**To:** Vince Carrica  
**Subject:** Unser pond details

**DRB PROJECT NO: 1002632**

EAST FLOOD WALL IN UNSER POND
TYPICAL SECTION
SC: NTS

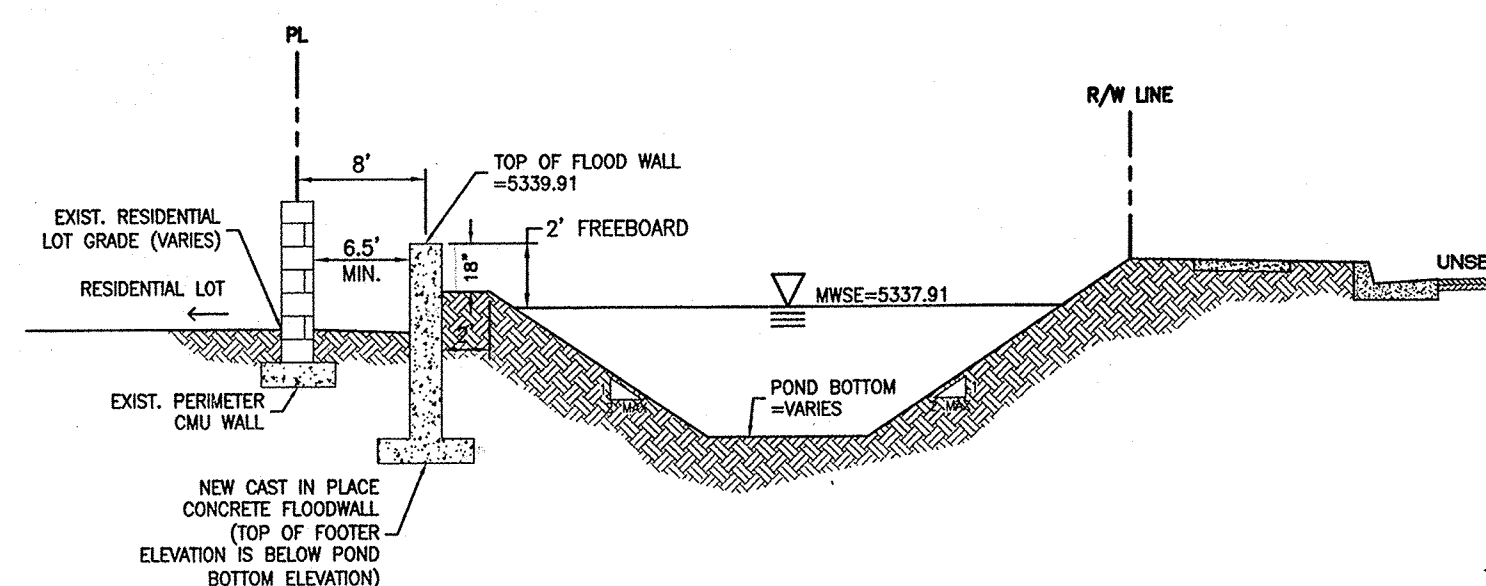
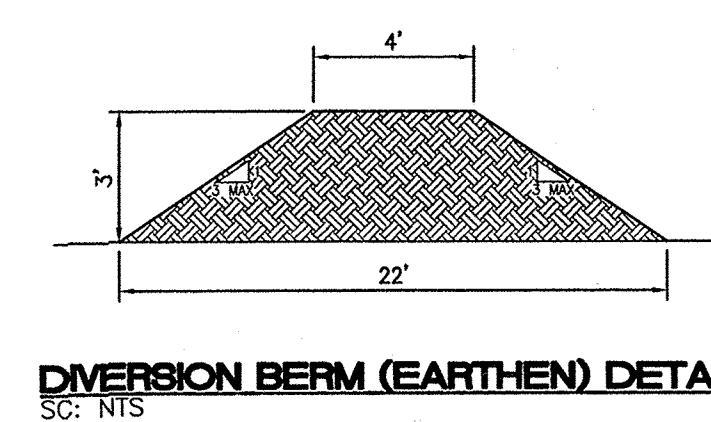
The wall on the east side of the pond is to be a continuous concrete floodwall-no block and be waterproofed. The top of footer as a minimum should be below the pond bottom and below the footer of the garden wall to the east. Is there a seepage concern that may affect existing structures?

There is a maintenance concern with the annulus between the walls. Wilfred says he needs at least 6.5 feet to get a skid steer in there. Or the area could be capped so there is no annulus.
